Engineers Comments Regarding Surface Water Drainage

Application Reference:	Y/37/25/DOC	Reviewer Reference:	ADC/EXT4
Planning Officer:	Hebe Smith	Date of Review:	14/11/2025
Site Name:	18 West View Drive Yapton BN18 0JR		
Application Description:	Approval of details reserved by condition imposed under reference Y/56/24/HH relating to condition number 3 - surface water drainage scheme.		
Assessment Number:	2 of 2

Application Reference: Y/37/25/DOC
Site Name: 18 West View Drive Yapton BN18 0JR

Drawing Number MGS - Y/56/24 - rev02

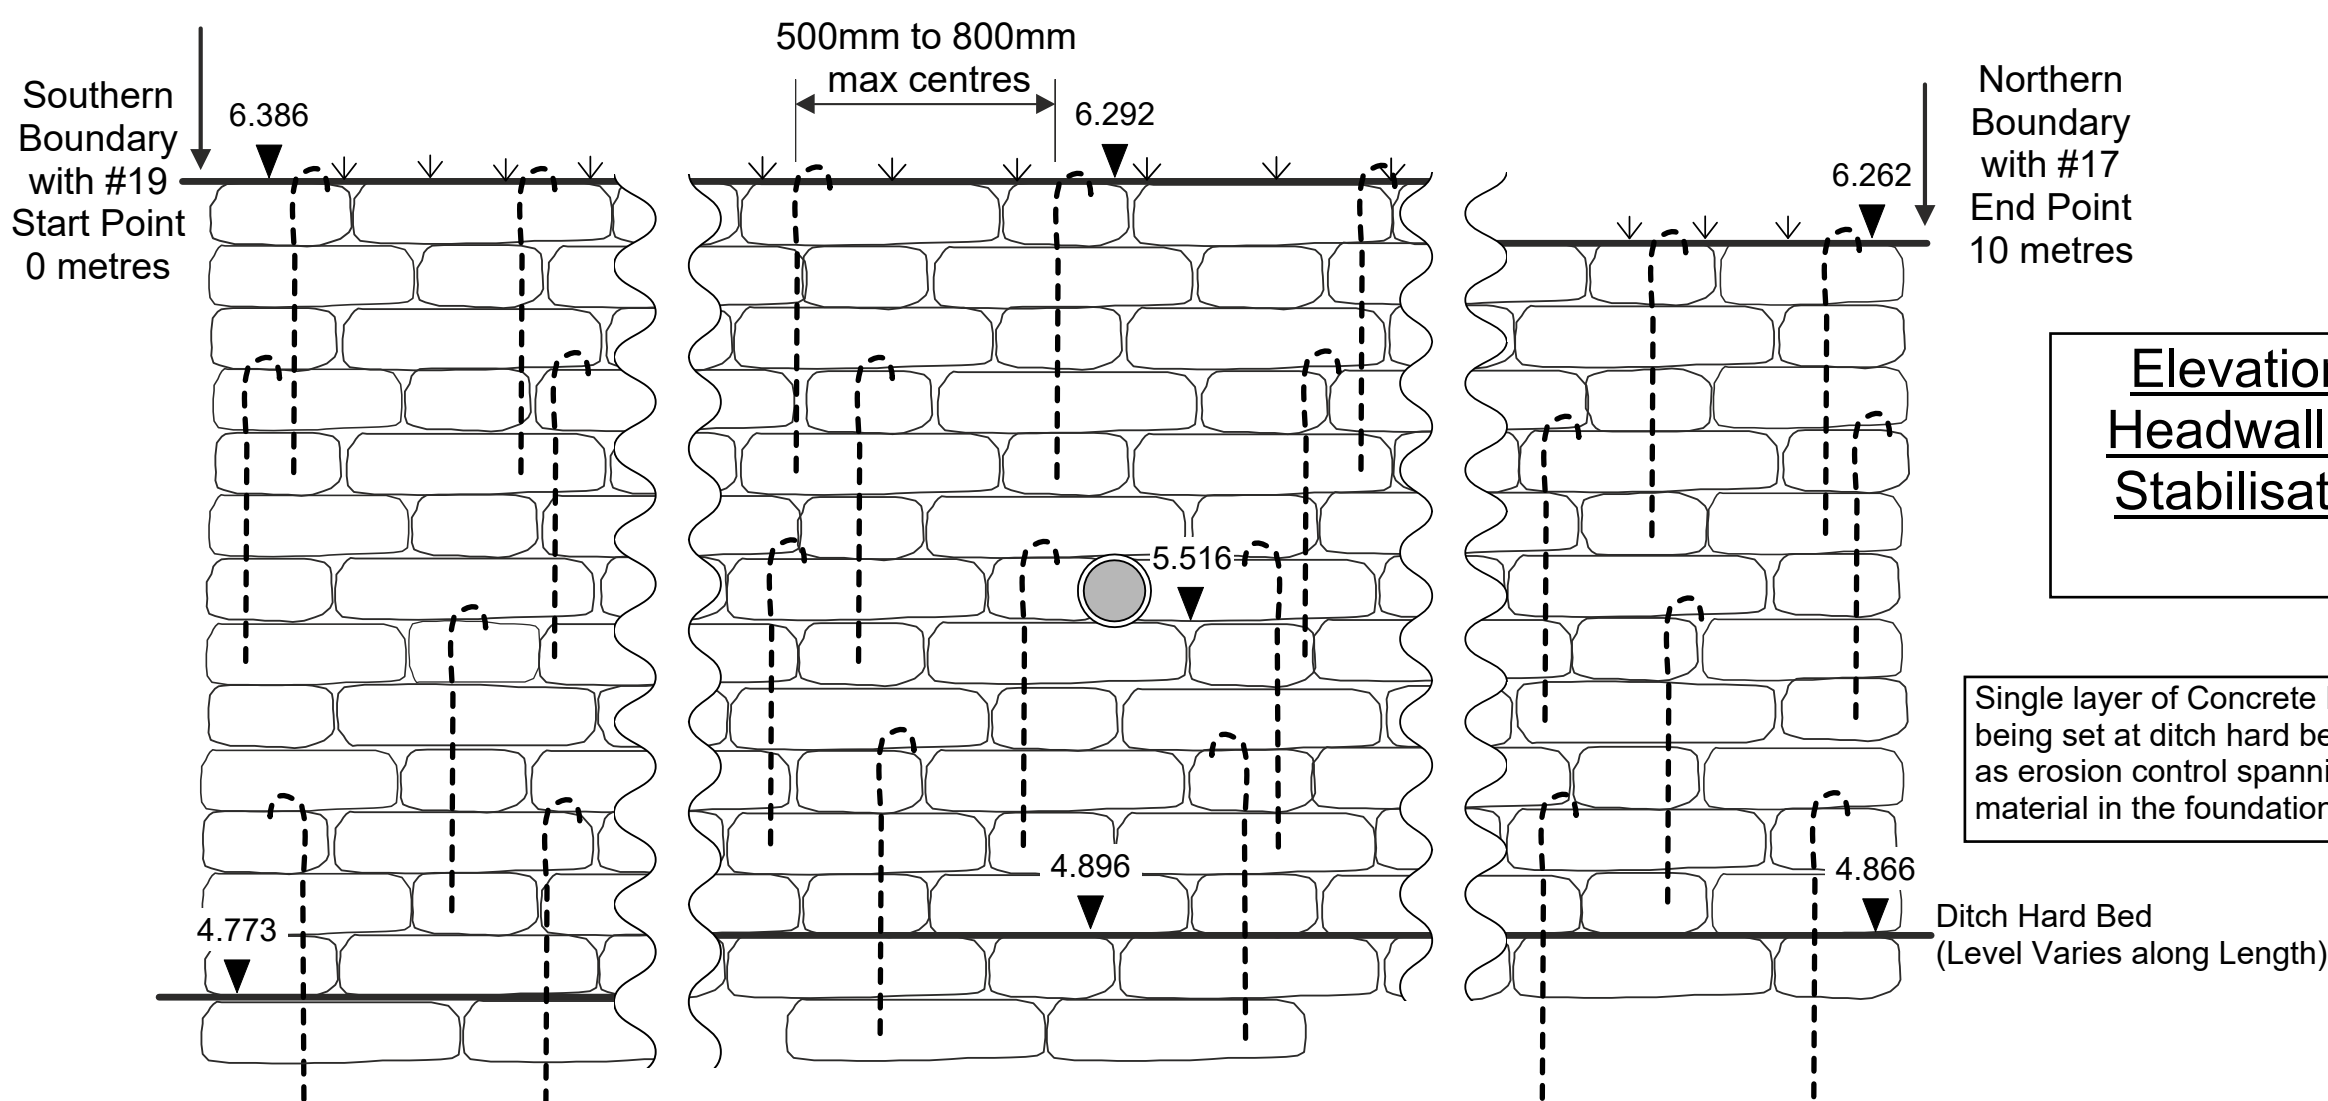
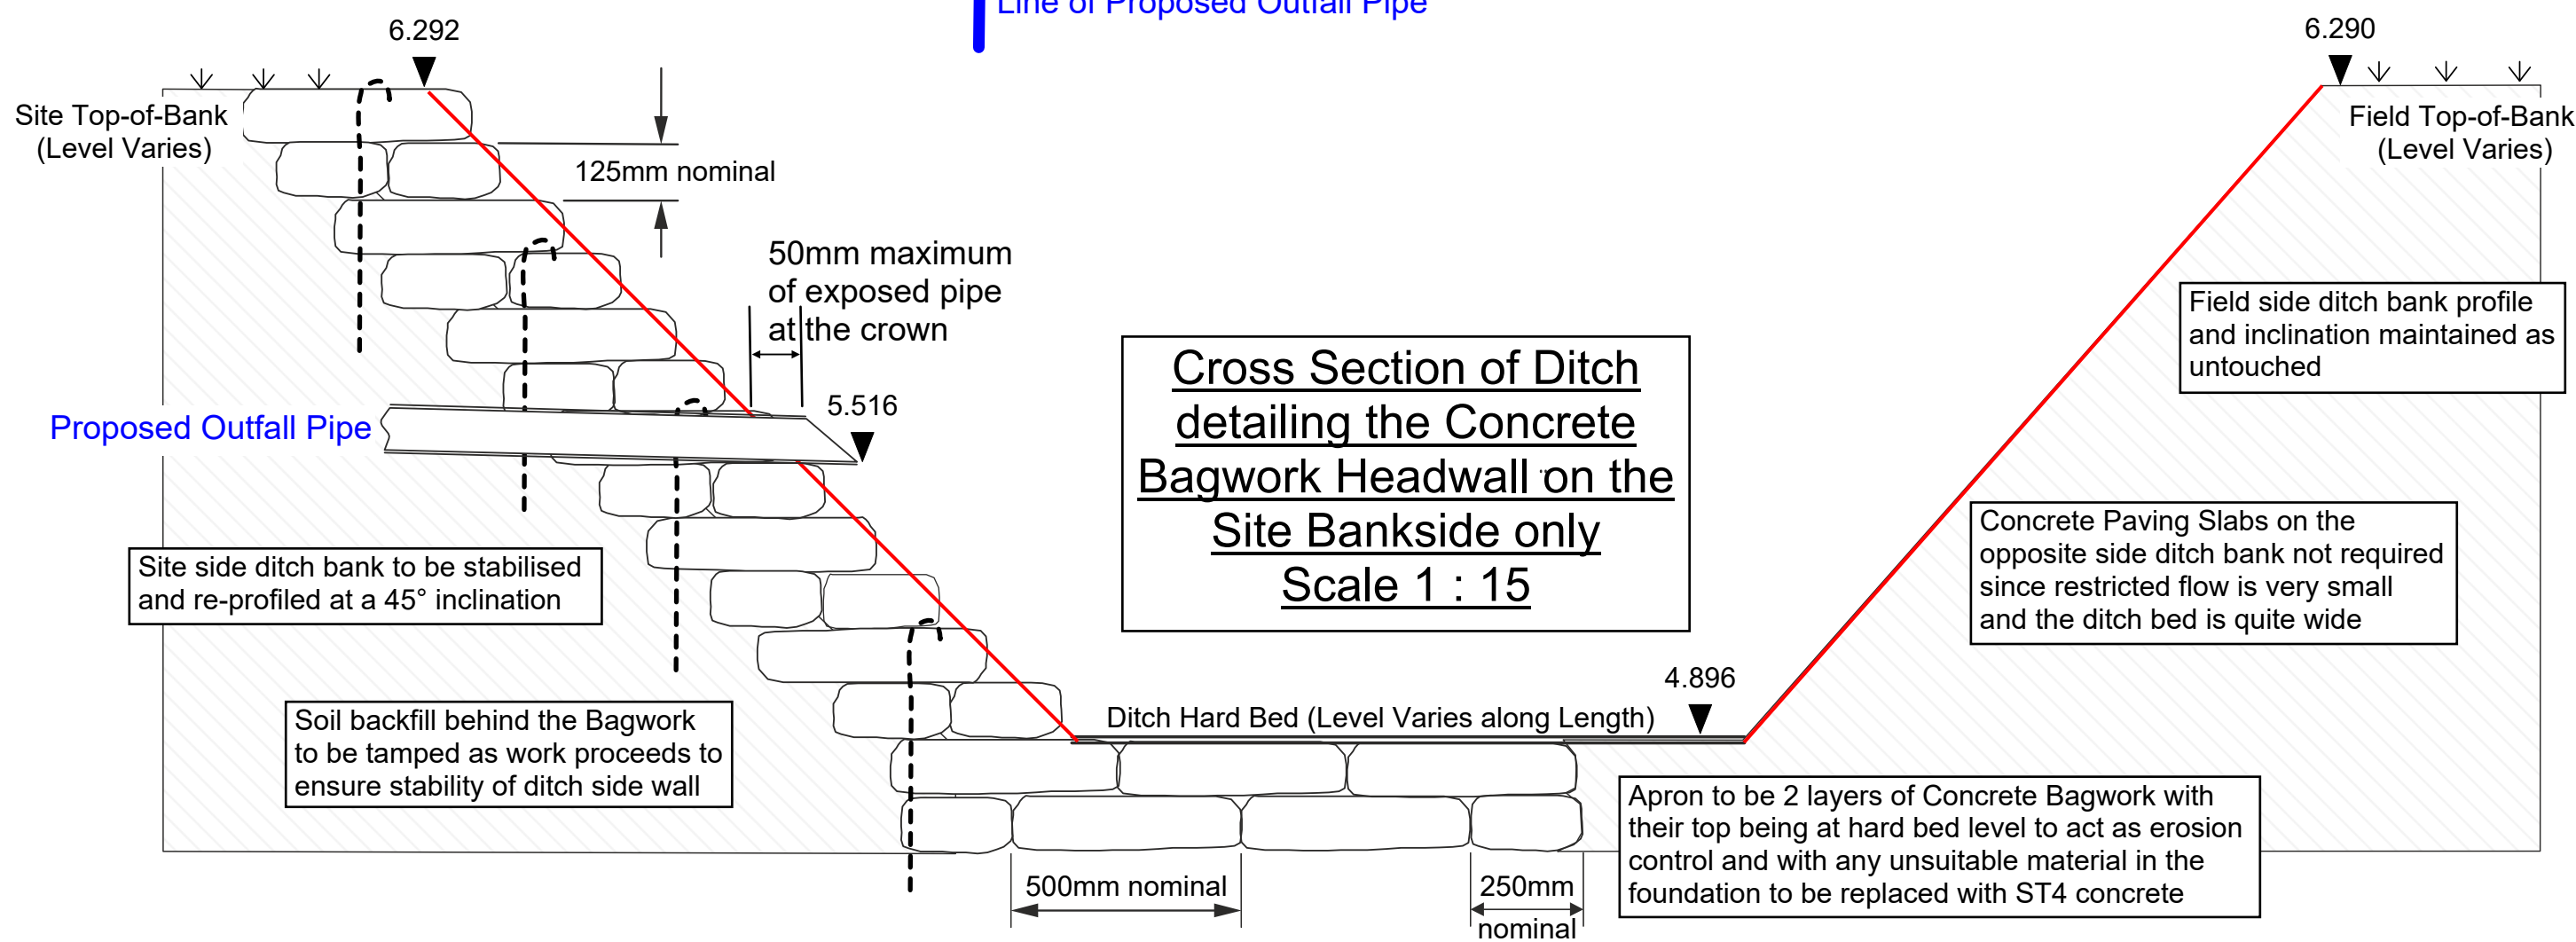
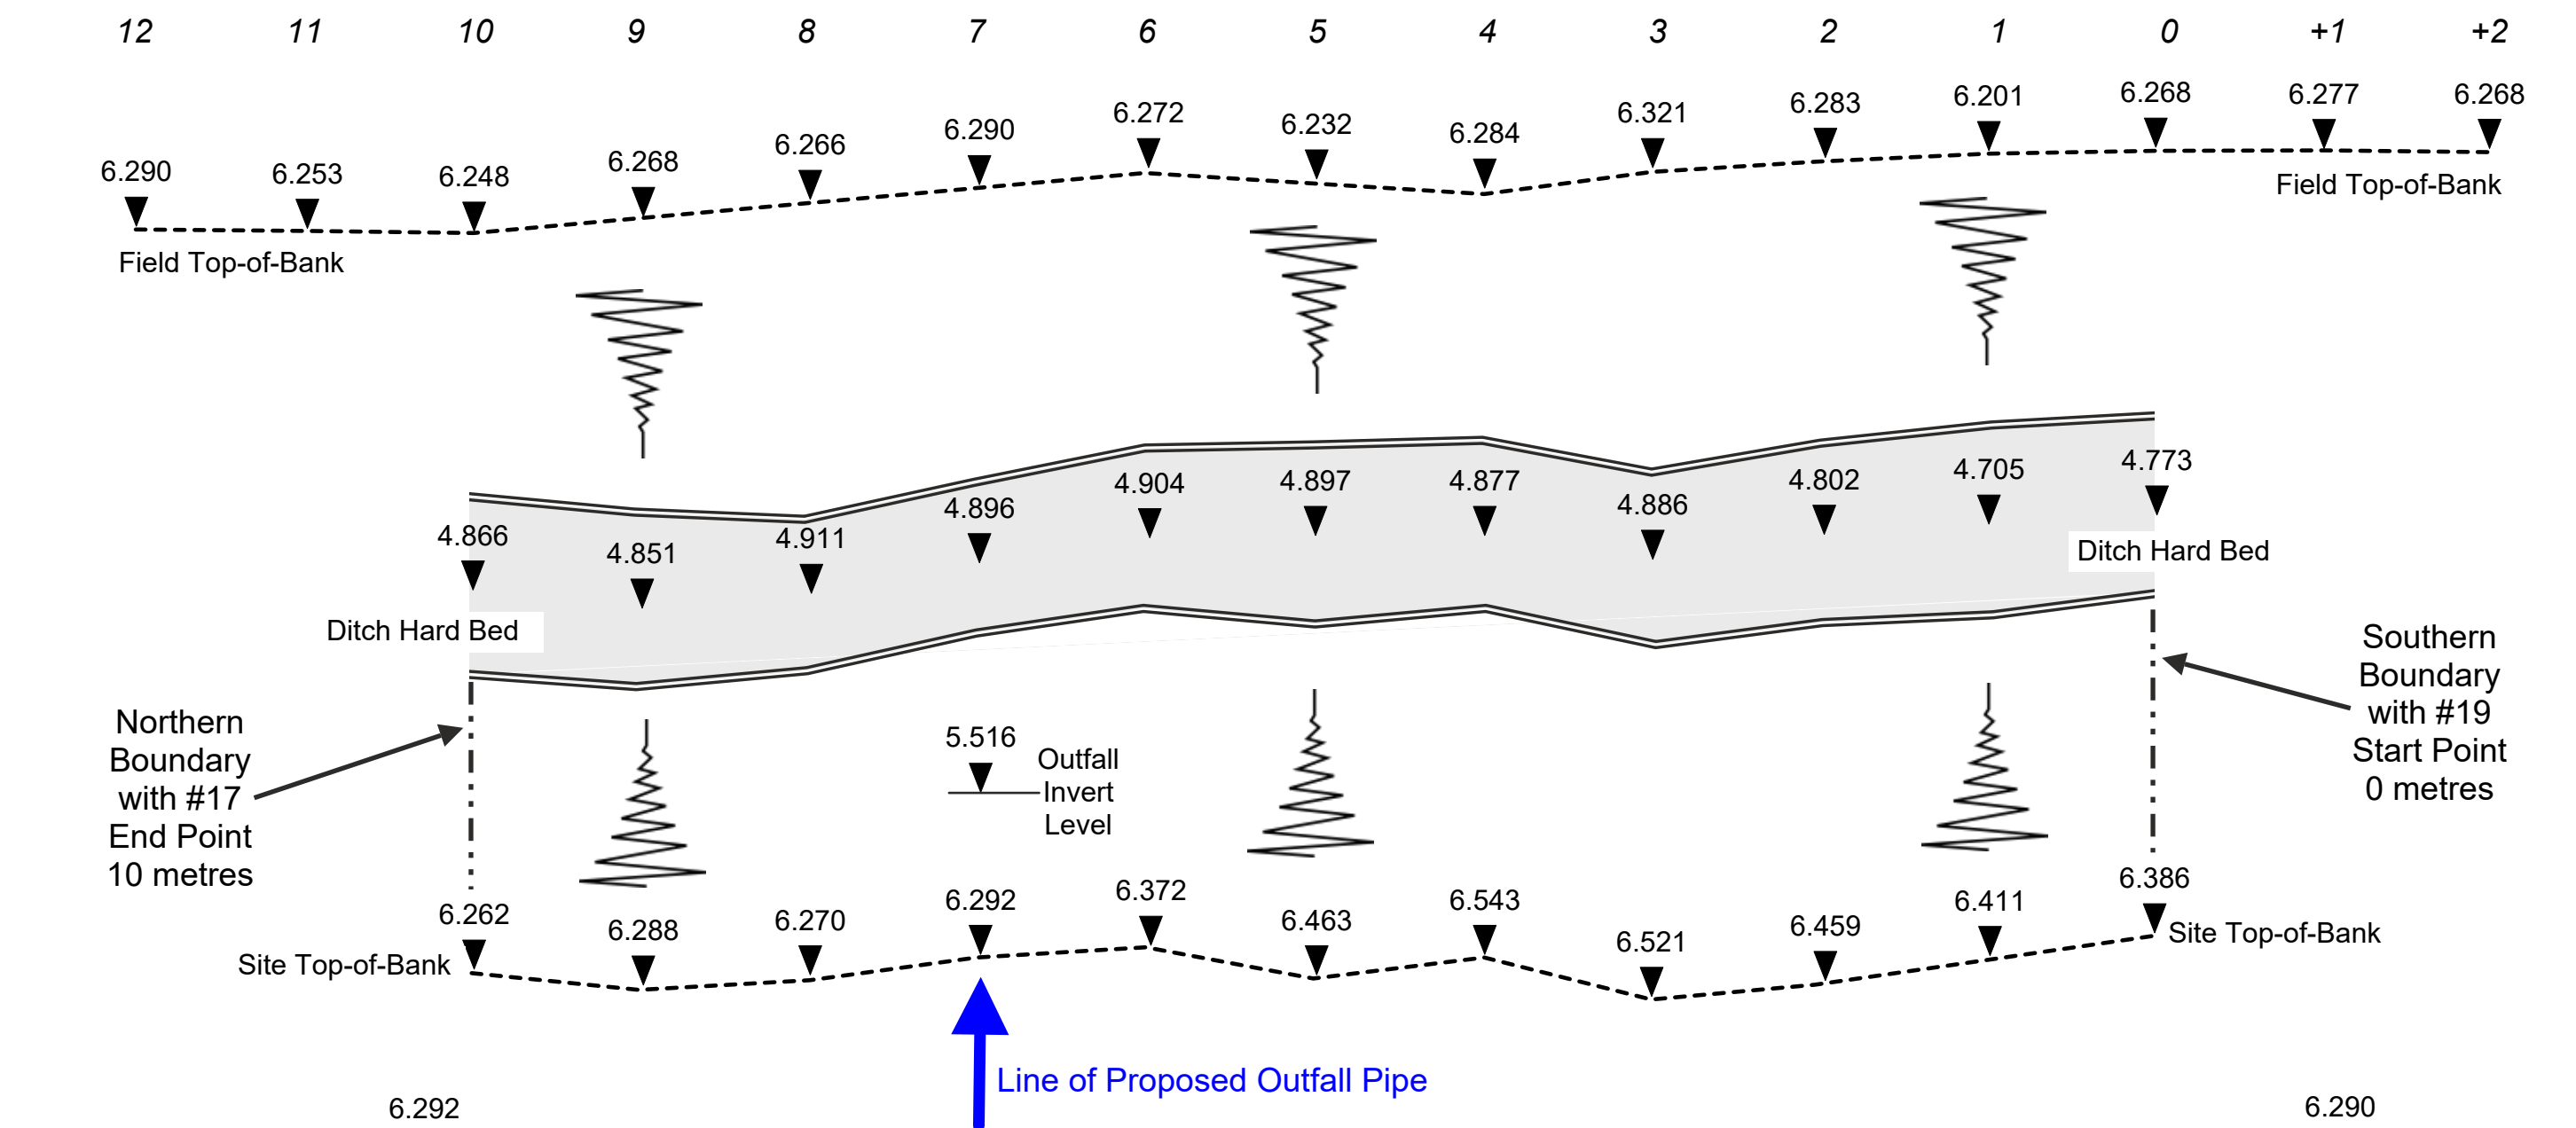
3.	The proposed headwall outfall and works appear to lie outside of the application boundary and potentially outside the extent of ownership of the applicant. Clarification on the extent of proposed works for the construction of the new headwall will be required including either confirmation of land ownership or 3 rd party permissions if application. Please note that the construction of the new headwall will require a and Ordinary Watercourse Consent from West Sussex County Council	The proposed headwall outfall and works lie within the extent of ownership of the applicant. The planning redline application boundary is overlaid onto an OS schematic which only give a basic outline of the ditch. Since the headwall and outfall do not actually protrude into the ditch volume itself only Watercourse Bylaw Consent to Arun DC was required but it was considered that full OWLDC to WSCC would be more appropriate. It should be noted that WSCC approved the consent on the 27th June 2025 with LDC-2025-038	Noted item closed
